WEST SUSSEX COUNTY COUNCIL CONSULTATION

TO:	Arun District Council FAO:Anita Gardner
FROM:	WSSC - Highways Authority
DATE:	16th September 2020
LOCATION:	Land East of Bilsham Road & land adjacent to Little Meadow Bilsham Road Yapton
SUBJECT:	Y/70/20/OUT Outline application with some matters reserved for 83 No. dwellings (81 net gain, retaining Oak Trees & Little Meadow), extension of existing light industrial/commercial processes building & new Village Hall. This application may affect the setting of a listed building & is a Departure from the Development Plan.
DATE OF SITE VISIT:	
RECOMMENDATION:	More Information
S106 CONTRIBUTION TOTAL:

FIGURE 2
Proposed new access

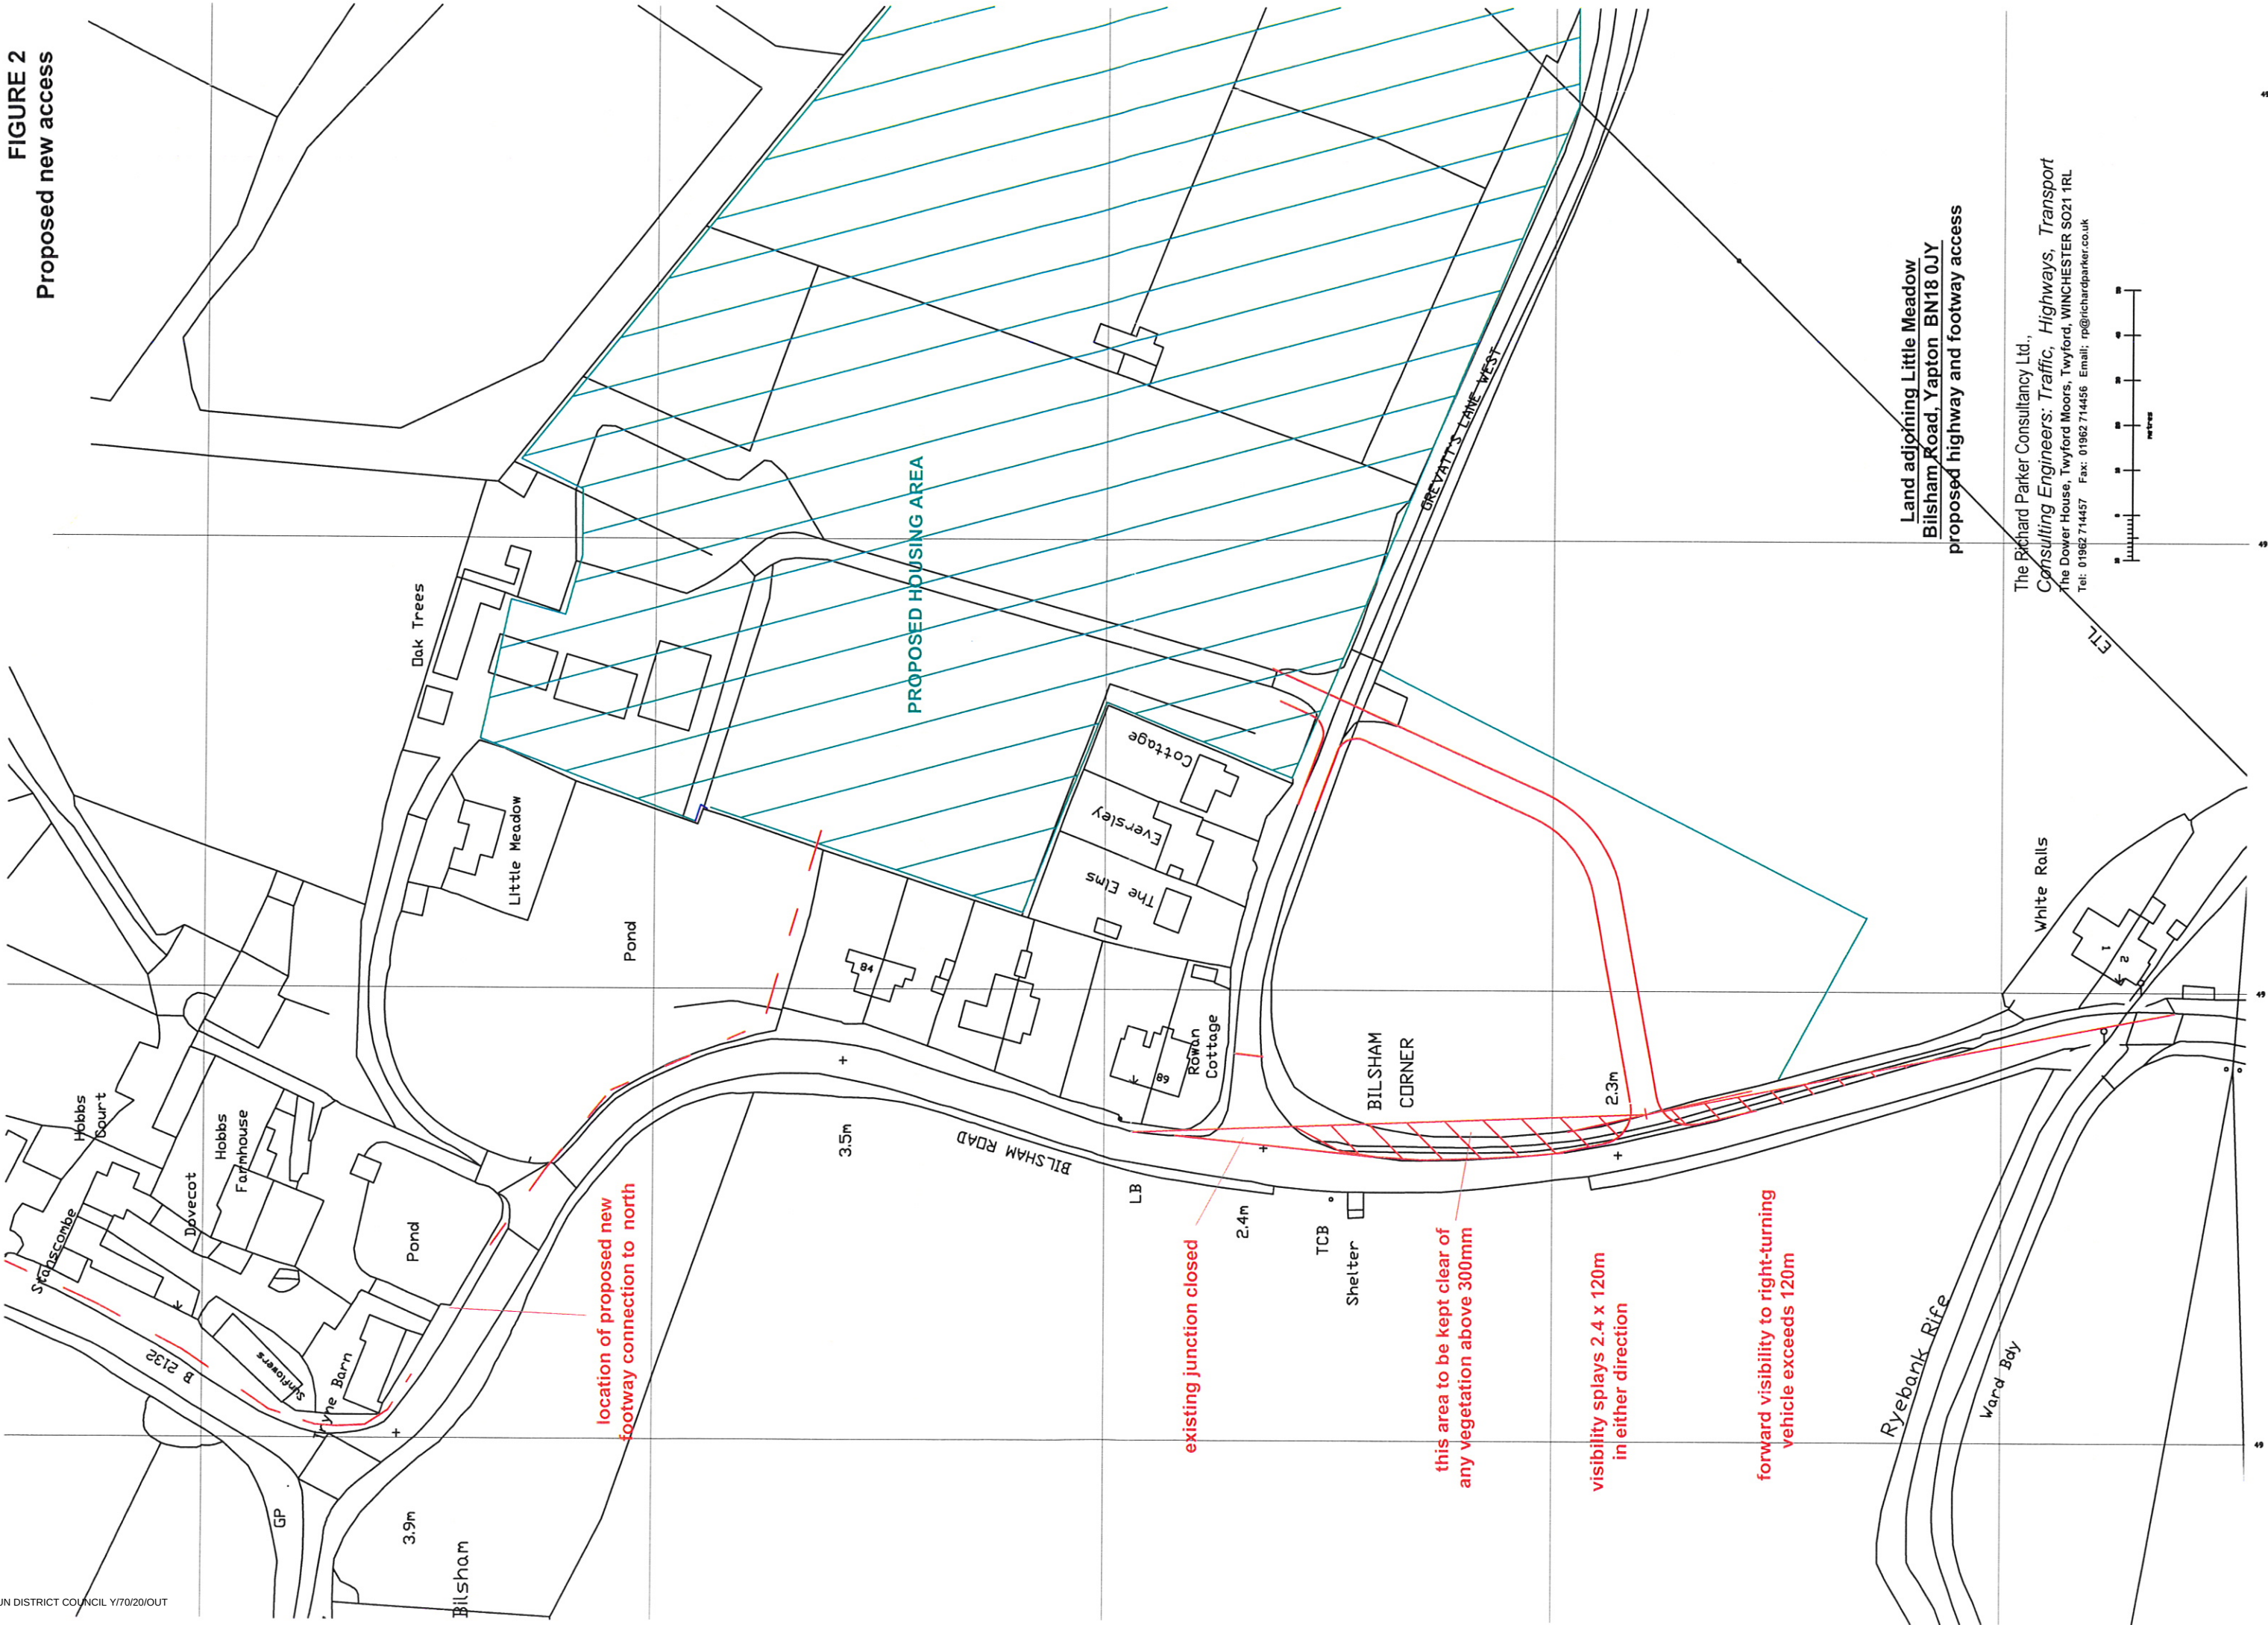
The existing principal access to the site from Bilsham Lane is from the junction with Grevatts Lane West. This junction has substandard visibility. The applicant proposes that this access will be closed and a new junction proposed 100m to the south, where it is claimed visibility is likely to be increased over the existing arrangement. The proposals are supported by way of a Transport Appraisal which has been produced as part of a pre-application however the LHA have not previously commented on this site as part of a pre-application with ourselves. The Appraisal acknowledges that its content is not a full Transport Assessment (TA), the LHA would request such a document is produced in support of the proposals.

- Stage 1 Road Safety Audit on the access arrangements. This should be undertaken in accordance with GG119 parameters and include a Designers Response.
- Detailed plan of access based on visibility splays in accordance with a speed survey along Bilsham Road
